Ref: 21-966

FORWOOD FARM, TRESWELL, RETFORD, DN2 0EE

An inspection of Forwood Farm was carried out during Tuesday 28 September 2021; the inspection being undertaken in order to comment upon the overall structural stability of the property. The subsequent report being prepared in order to satisfy a Planning Application requirement.

1) North East Elevation (Scale 1:100)

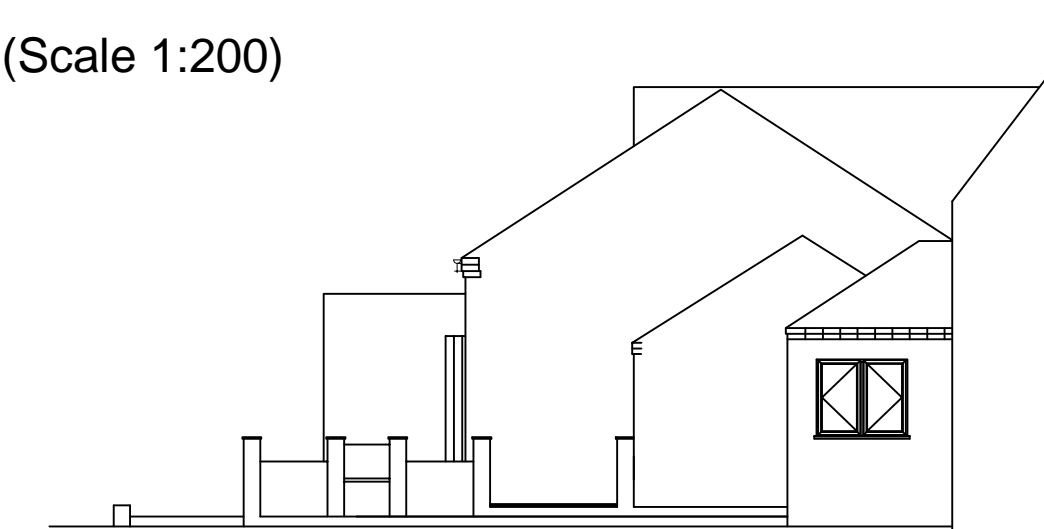
North East Elevation

- To the North East elevation are two small openings (to the lower floor area). The openings have no lintels to support the above brickwork. Support is currently being provided by the timber frames.
- To the extreme left-hand end of the North East elevation and at first floor level is a pattress plate. This has a tie bar which extends through to the opposing solid wall.
- Adjacent to the return of the South East elevation the North East elevation is showing lateral deflections with maximum deflections tending to occur at about first floor level. The maximum deflection was measured at approximately 25mm. Deflections reduced to zero at ground level and eaves. The

pattern plate and tie bar have most probably been inserted as a result of the deflections.

4) South East Elevation (Scale 1:100)

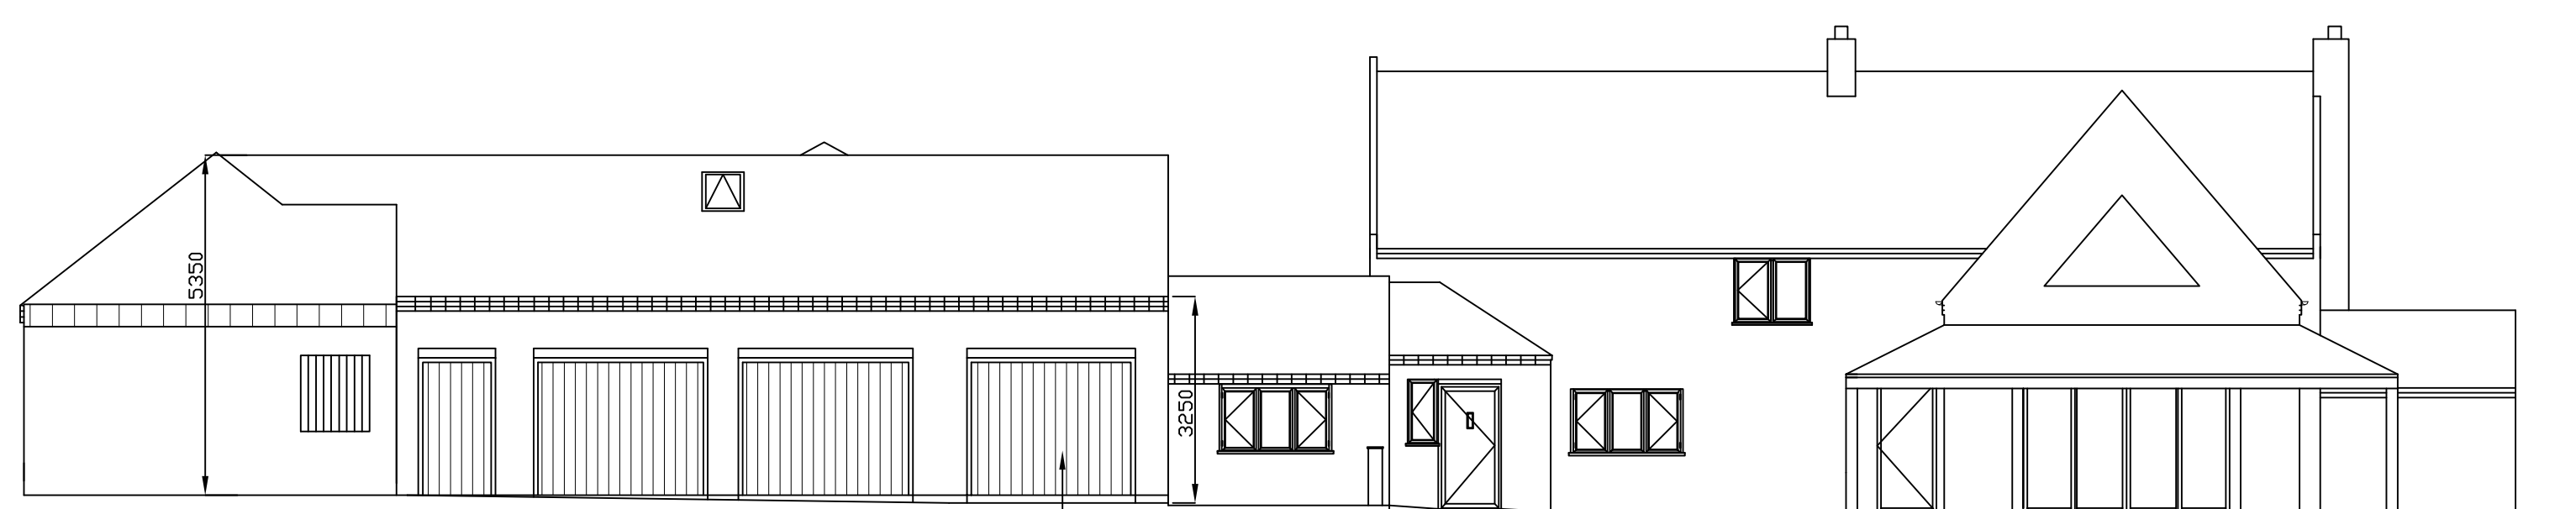
### South East Elevation

- To the right of the South East elevation is a two storey element with, at one time, two arched entrances to the ground floor. Most likely to increase the workable size of the openings, the relatively large central brick pillar has been removed and replaced by a central steel circular section prop plus horizontal steelwork to support the first floor brickwork etc.

- To the right hand steel support (as looking directly onto the elevation), a short length of vertical cracking was evident (very adjacent to the return North East elevation).

- Further cracking was observed extending upwards from above both first floor windows with the cracking tending to slope upwards in the direction of the North East elevation.

- Beneath the right hand first floor window opening some vertical cracking was observed extending up from the steel horizontal support.
- Within the open garage areas to the single storey element of the elevation, inclined cracking was observed in the panel of masonry. The cracks were observed to slope upwards towards the North East Elevation.

- We would consider that cracking affecting the South East elevation plus deflections affecting the North East elevation are most likely due to the activities of removing the masonry support to the ground floor wall. This masonry pillar split the two arched openings into the South East elevation and carried the load of the first floor elevation wall etc. The replacement of the brick pillar by steelwork has probably allowed some deflections both in the replacement horizontal steelwork and also likely possible deflections in the central steel support. Associated rotation of the horizontal members has most likely created the lateral deflections affecting the North East elevation. General vertical deflections are most likely the cause of the cracking evident in the first floor area.

Deflections affecting the two story section of the South East elevation will require addressing. Long term viability of the existing (and retro fitted) steel frame cannot be guaranteed. It is possible that the steel frame could be replaced with a more suitable structure, but this would most probably have a negative impact on the viability of the conversion. In this instance the more appropriate option would be to take down the elevation and rebuild. The rebuild could also extend around the North East elevation to eliminate the lateral deflections. On completion of the work the 'existing' patras plate and tie bar can be removed.
